EPC STORMWATER REVIEW COMMENTS IN ORANGE BOXES WITH BLACK TEXT

# THE LANDINGS OF DENMARK

## FILING NO. 2 - UPDATED PLANS

## GRADING & EROSION CONTROL PLAN

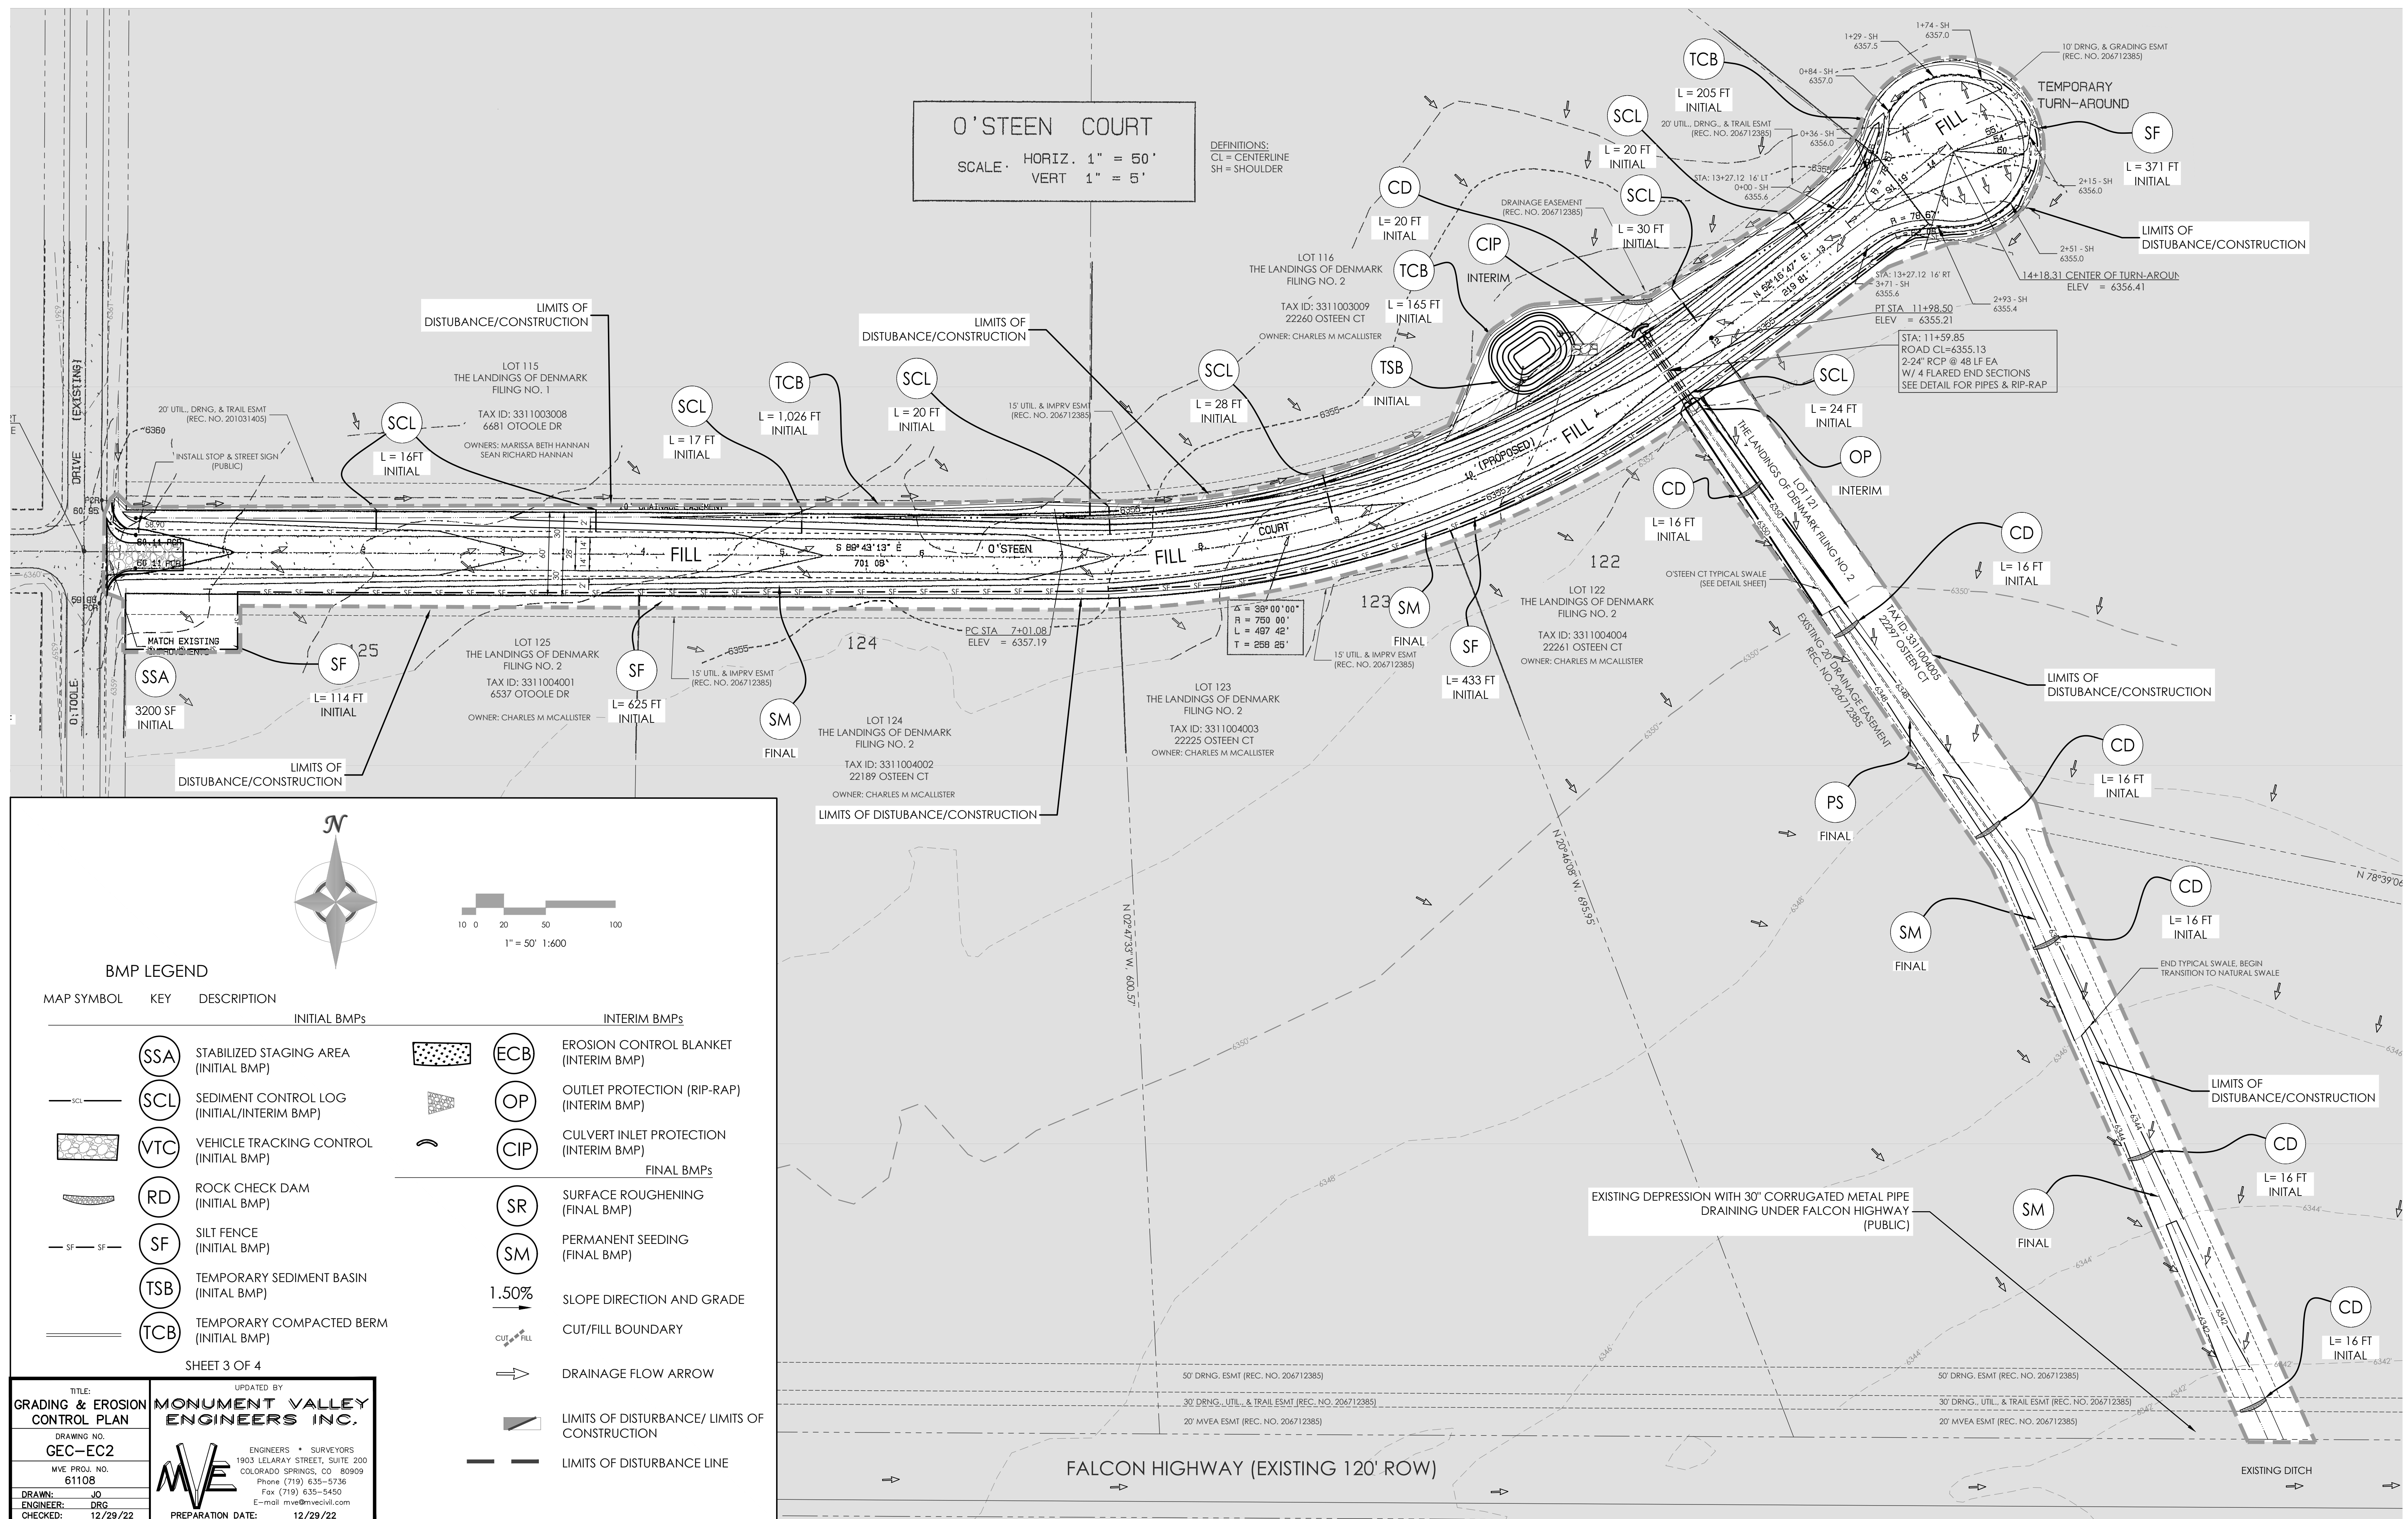
Unresolved: Show 100-Year WSEL and the symbol on Legend.

Unresolved: Silt fence should be parallel to contours. Placement as shown could channelize runoff. All silt fence not running parallel to contours shall be installed with J-hooks.

Unresolved: Show 100-Year WSEL and the symbol on Legend.

Unresolved: Silt fence should be parallel to contours. Placement as shown could channelize runoff. All silt fence not running parallel to contours shall be installed with J-hooks.
